Please ask for: Ms Iqraa Malik
Email: iqraa.malik@terraquest.co.uk
Telephone: 01212341390
Our Ref: R/130/21/HH
Your Ref:
Date: 2nd June 2021

Application for Planning Permission for Works or Extension to a Dwelling

Development: Single storey rear extension and raised deck, garage conversion to include replacement of garage door with window
Location: 12 Albert Road Rustington BN16 3JS

02 Block Plan
Scale: 1:500

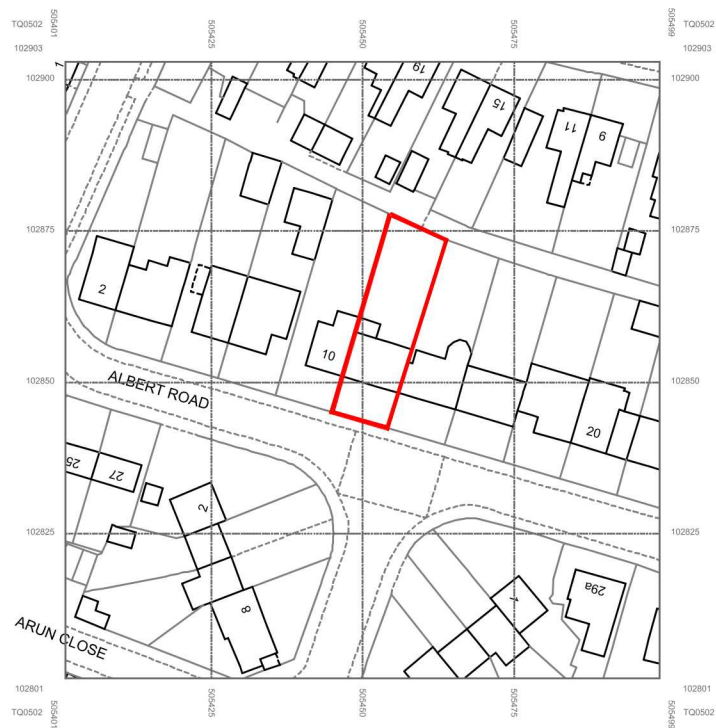
Block Plan

You are required to have dimensions from the proposed extension(s) to all site boundaries. Please amend.
